**M1 Pacific Motorway extension to Raymond Terrace (SSI 7319)
Advice on the Environmental Impact Statement (EIS)**

Thank you for the request for advice from Public Authority Consultation (PAE-24749572), requesting the review by the NSW Environment Protection Authority (EPA) of the Environmental Impact Statement (EIS) for the proposed M1 Pacific Motorway extension to Raymond Terrace (Application SSI-7319).

ATTACHMENT A: EPA COMMENT ON EIS FOR M1 PACIFIC MOTORWAY EXTENSION TO RAYMOND TERRACE (SSI 7319)

Location: L08 - 838 Tomago Road, Tomago

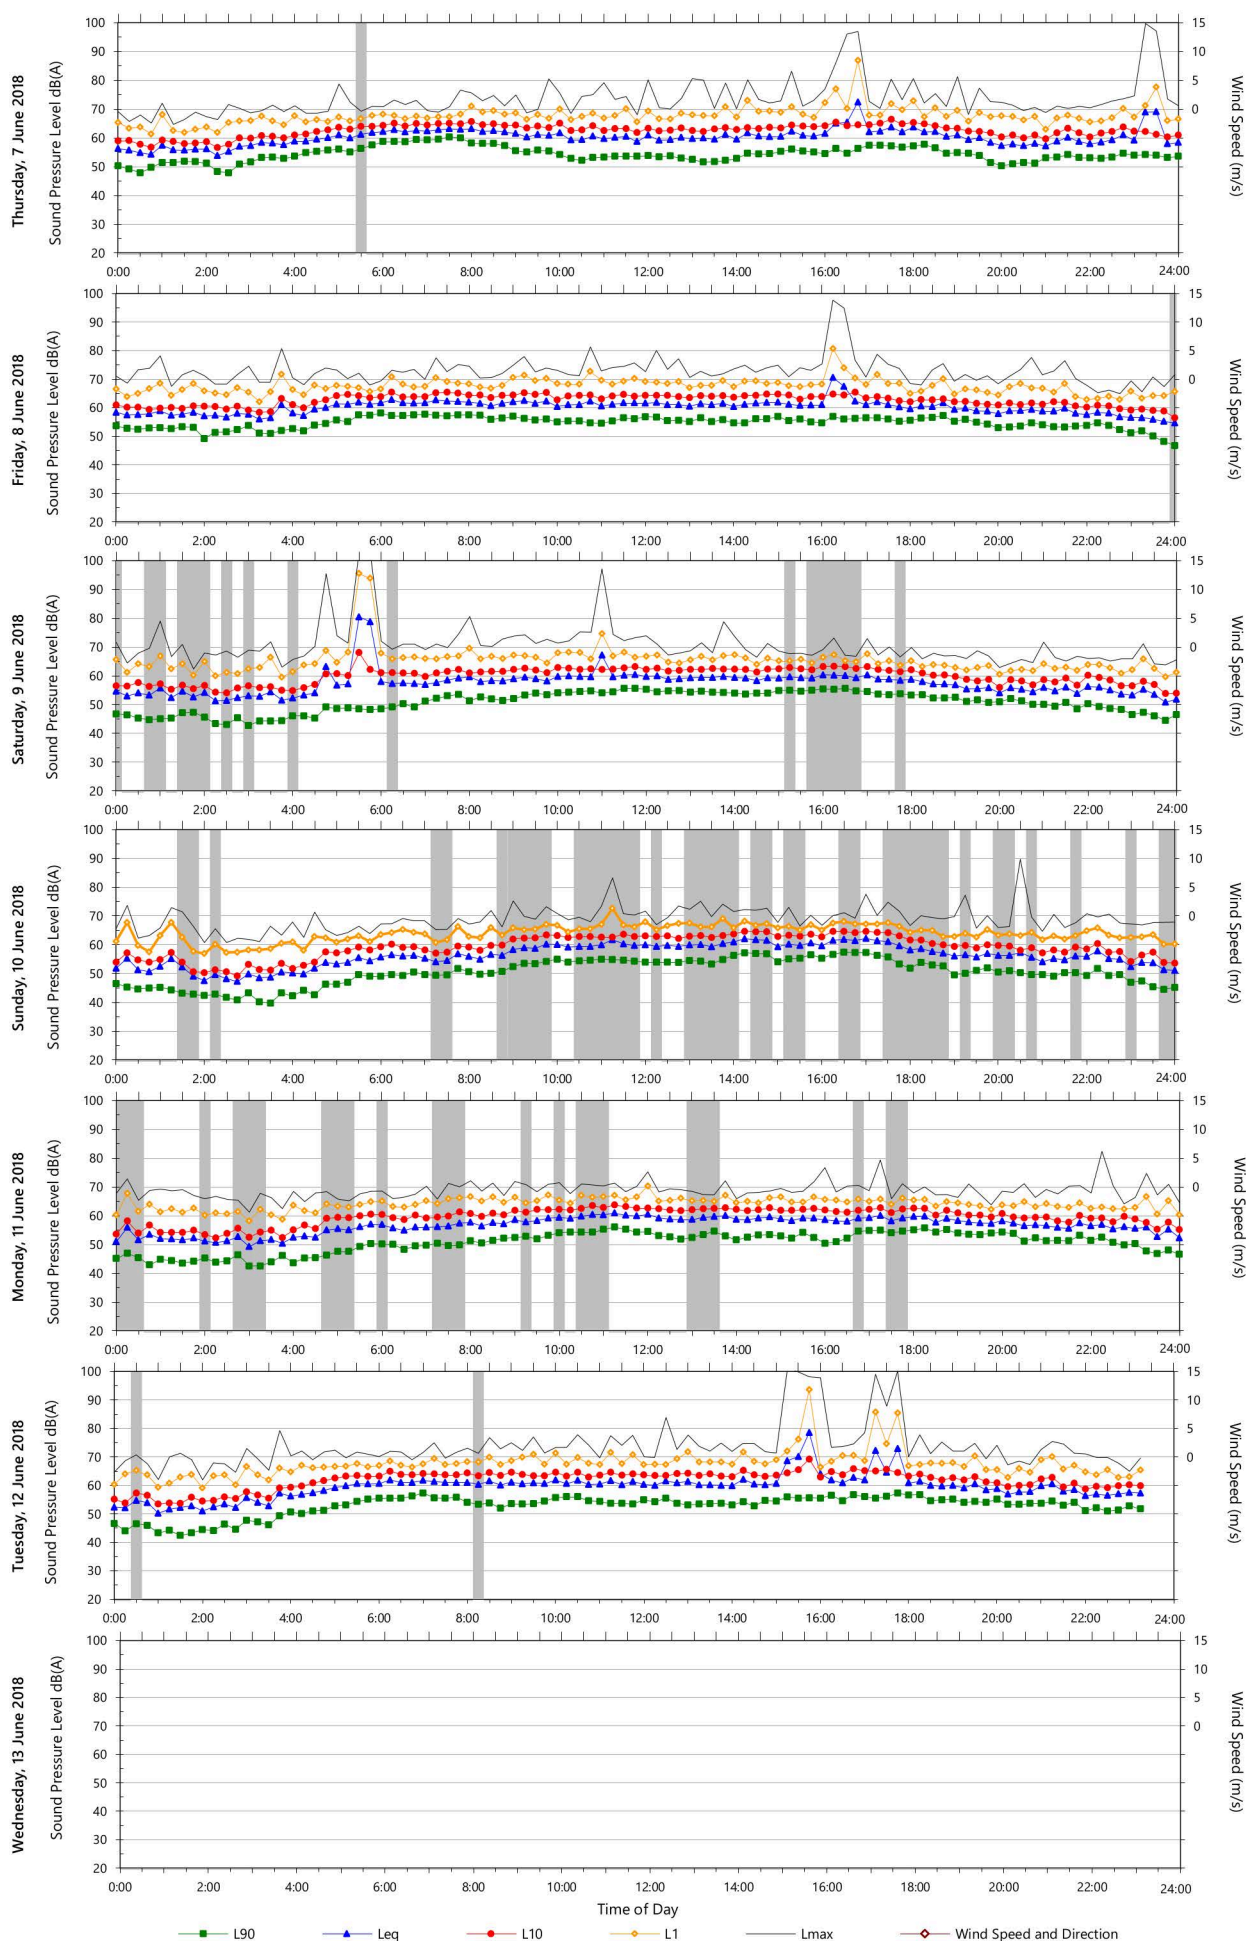
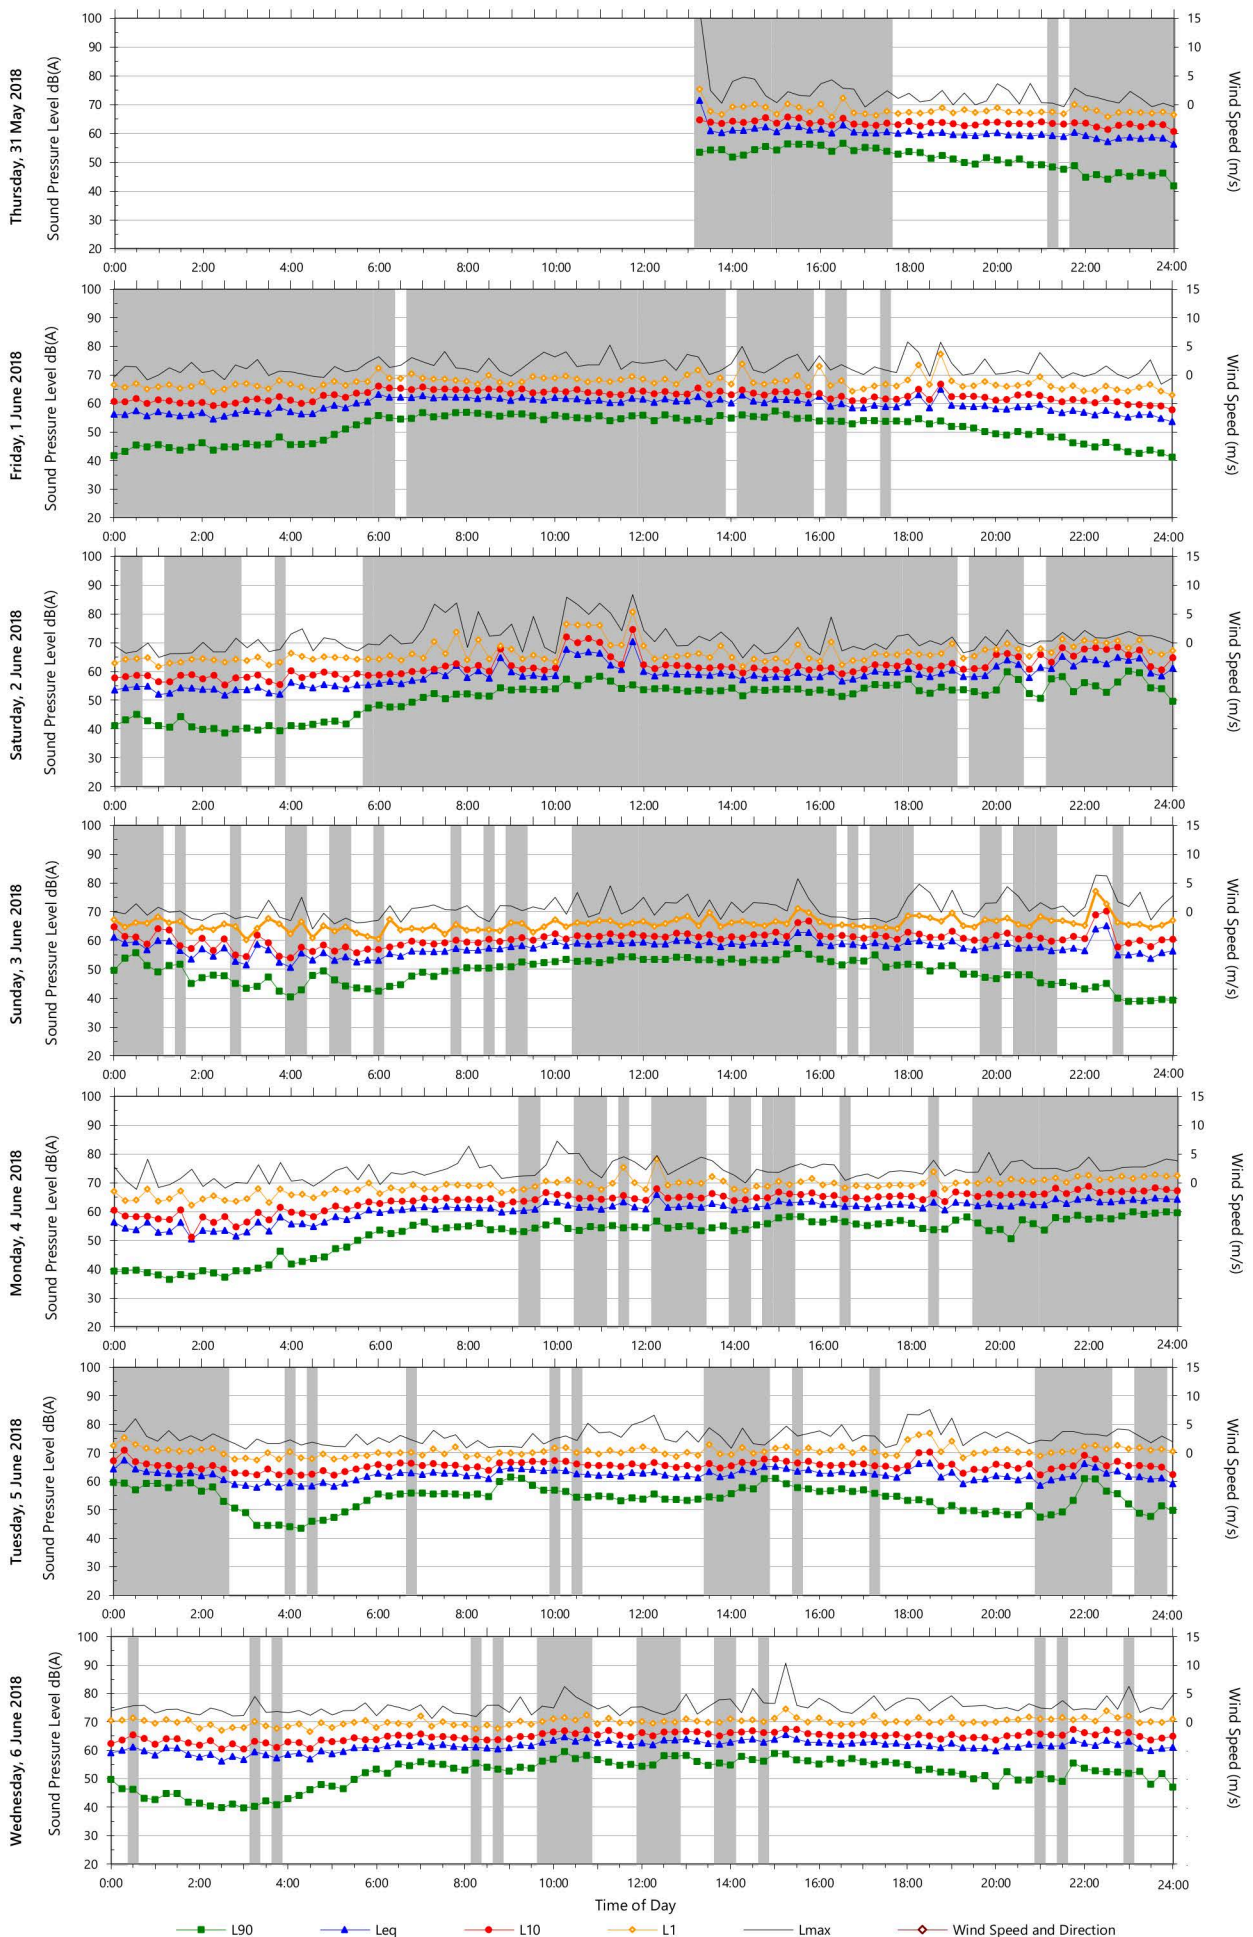
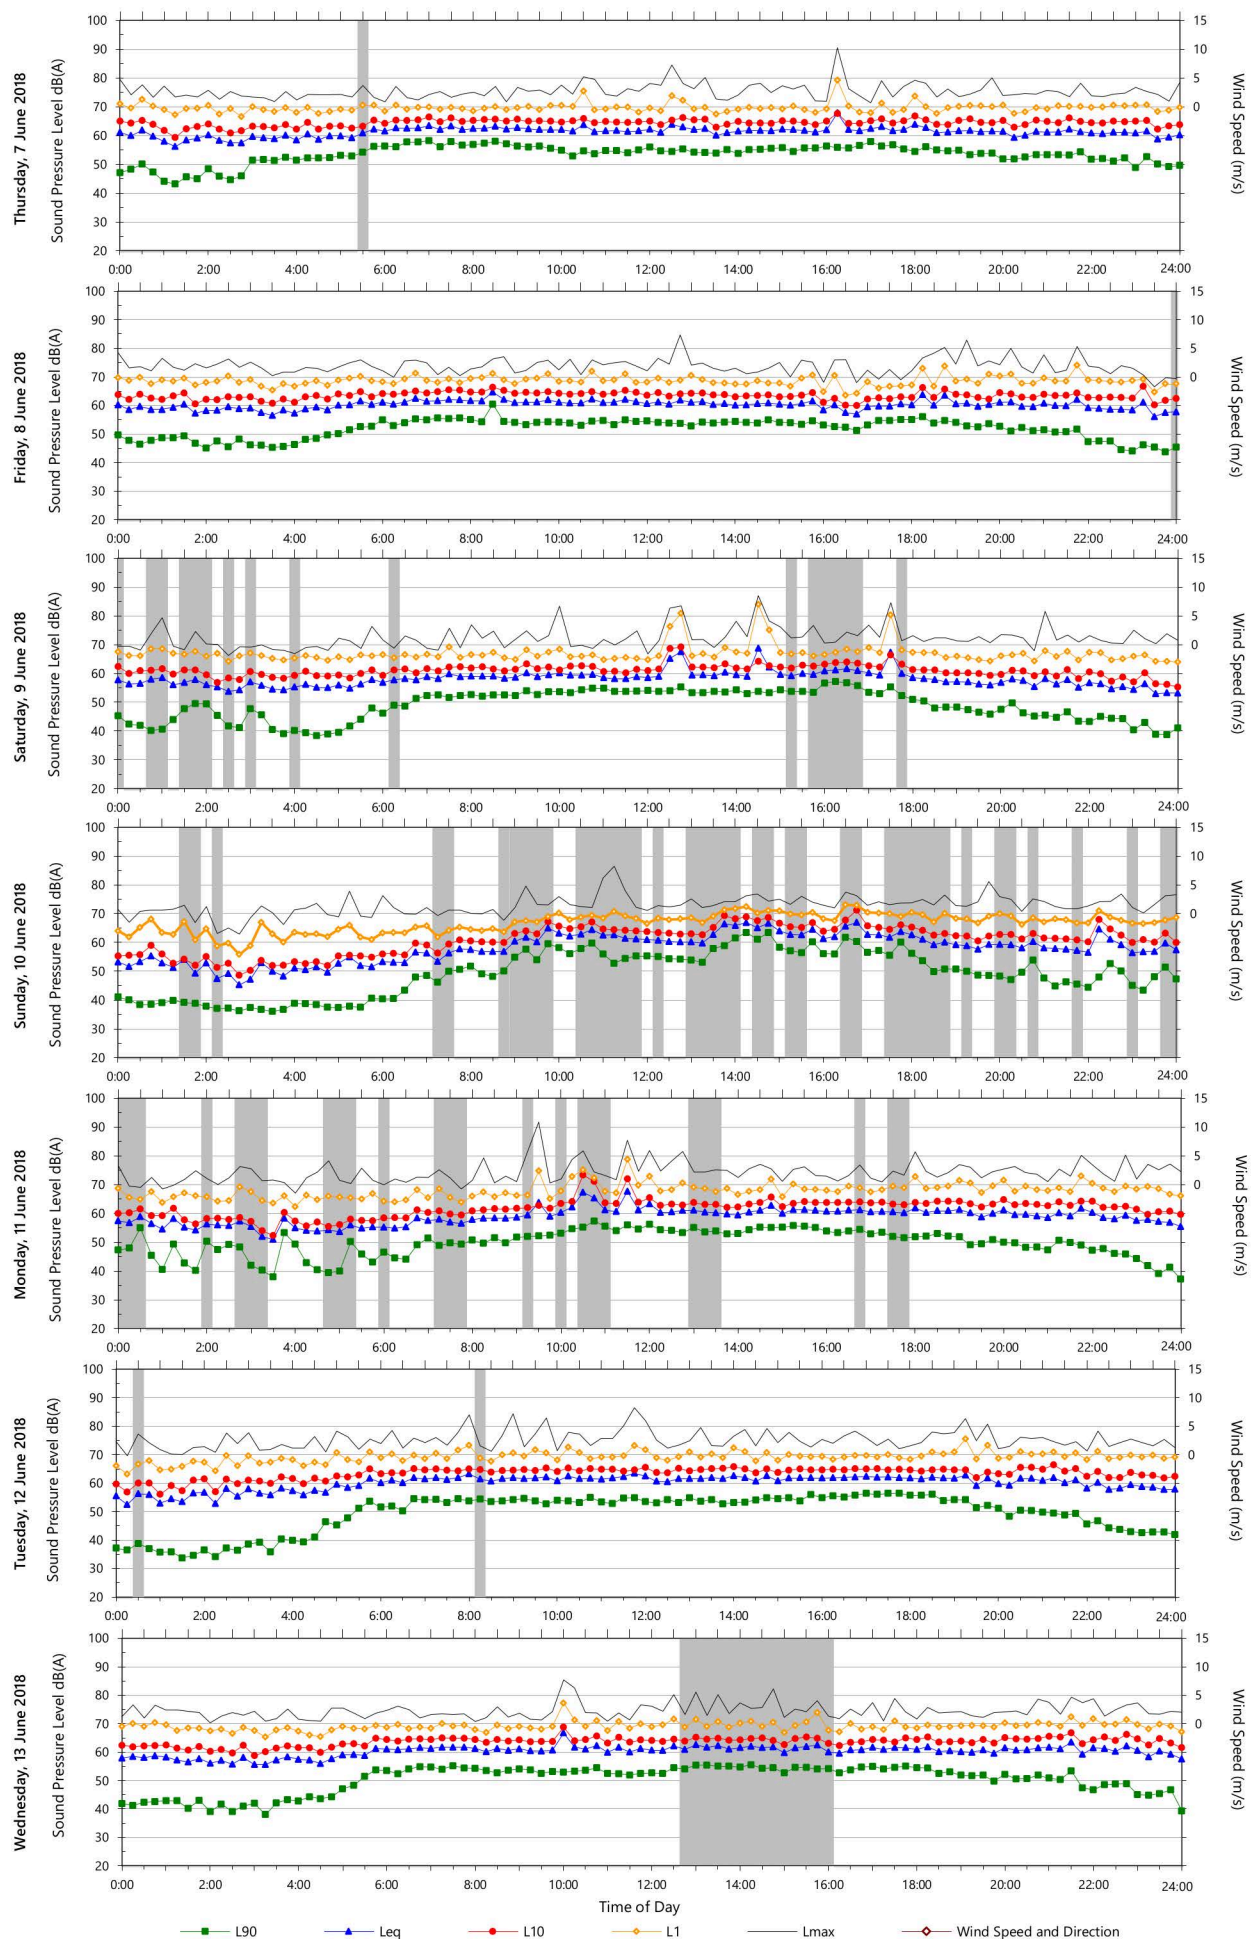
A review of the noise monitoring graphs in NIA Appendix B.2 indicates that further justification for the adequacy of noise monitoring presented or additional information is required.

A significant amount of data appears to have been excluded due to either inclement weather or extraneous noise. The EPA is concerned that the extent of data excluded means that it may not be representative of long term background noise levels, and therefore its suitability to be used to establish reliable noise management levels could be called into question.

Locations L01 to L014 (inclusive) appear to have no more than 5 and in some cases less than 3 valid periods out of the total monitoring duration. Locations L15 to L20 appear to be less affected, however there it is still not clear if sufficient valid data has been presented.

Fact Sheets A and B in the Noise Policy for Industry (NPfI) set out the EPA's requirements for establishing background noise levels. Due to the amount of data excluded, it is currently not clear if these requirements have been satisfied nor if sufficient valid data has been presented in order to establish representative background noise levels.

Noise monitoring was also conducted in 2016 for the purposes of measuring road traffic noise. Due to the amount of data excluded at Locations L13 to L20, further justification is needed that the remaining data, after invalid samples were excluded, provides sufficient amount of data to enable a representative calculation of the traffic noise descriptors.

The proponent reviews the noise monitoring data in the NIA in the context of the monitoring requirements set out in the NPfI and for each location and either:

- Provide a justification and demonstrate that the requirements of the NPfl have been fulfilled; or
- Provide additional data that fulfills the monitoring requirements in the NPfl.

The EPA also recommends that the proponent either:

- Provides justification and demonstrate that the data presented for road traffic noise descriptors is sufficient to be representative; or
- Provides additional valid data.
